## **22/O1682/F – Proposed Ground Mounted Solar Farm at Manor Farm, Noke**

# **Transport Technical Note – Response to Highway Authority Consultation Response**

Date: October 2022

Pegasus Reference: P19-2636 TRO2

Visibility Splays at Proposed Site Access

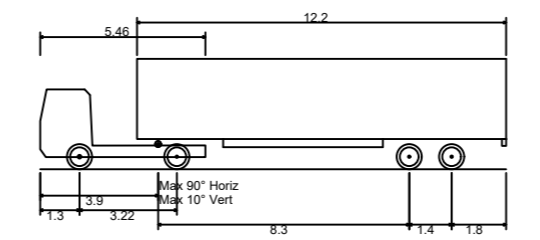
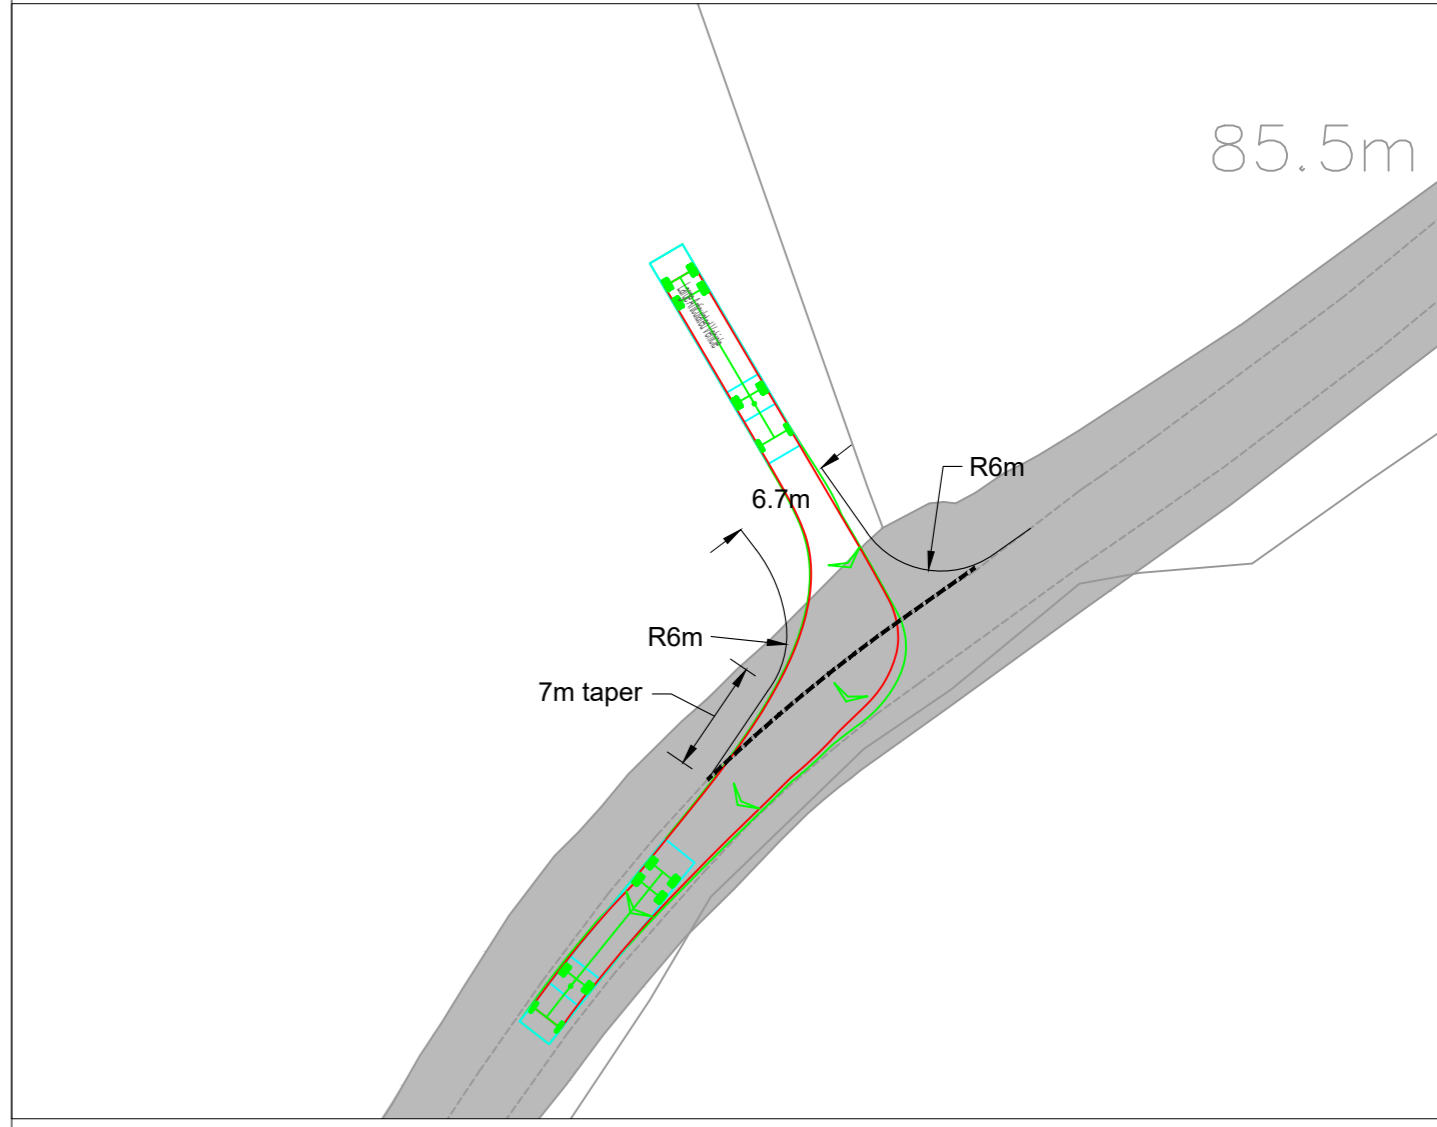
- 1.3. The comments received from OCC in relation to the application are as follows:
  - i. Speed surveys are required at the site access in order to inform visibility splays in accordance with 85<sup>th</sup> percentile speeds.

- ii. The north-eastern half of Noke Village Road reduces to approximately 4.5m wide and forms a slight “S” bend which restricts forward visibility, as well as visibility from the site access; and

2.4. **Table 2.1** demonstrates that the recorded 85<sup>th</sup> percentile speeds for both northbound and southbound vehicles is 29.25mph. Therefore, in accordance with Design Manual for Roads and Bridges (DMRB) requirements, visibility splays of 2.4 x 64.23 metres to the nearside kerb in both directions are required<sup>2</sup>.

2.5. Figure 2 of the CTMP has been updated to reflect the recorded speeds and visibility splay requirements, as shown at **Appendix B**. This confirms that the visibility splays can be achieved at the proposed site access. The visibility splays shown are considered to be robust on the basis that Manual for Streets (MfS) parameters are typically used for roads where speeds are less than 37mph.

2.6. With reference to OCC's comments, which suggested that a maximum visibility splay of 95 metres can be achieved looking right out of the site access due to the presence of a bank adjacent to the carriageway, the visibility splays are therefore considered appropriate.
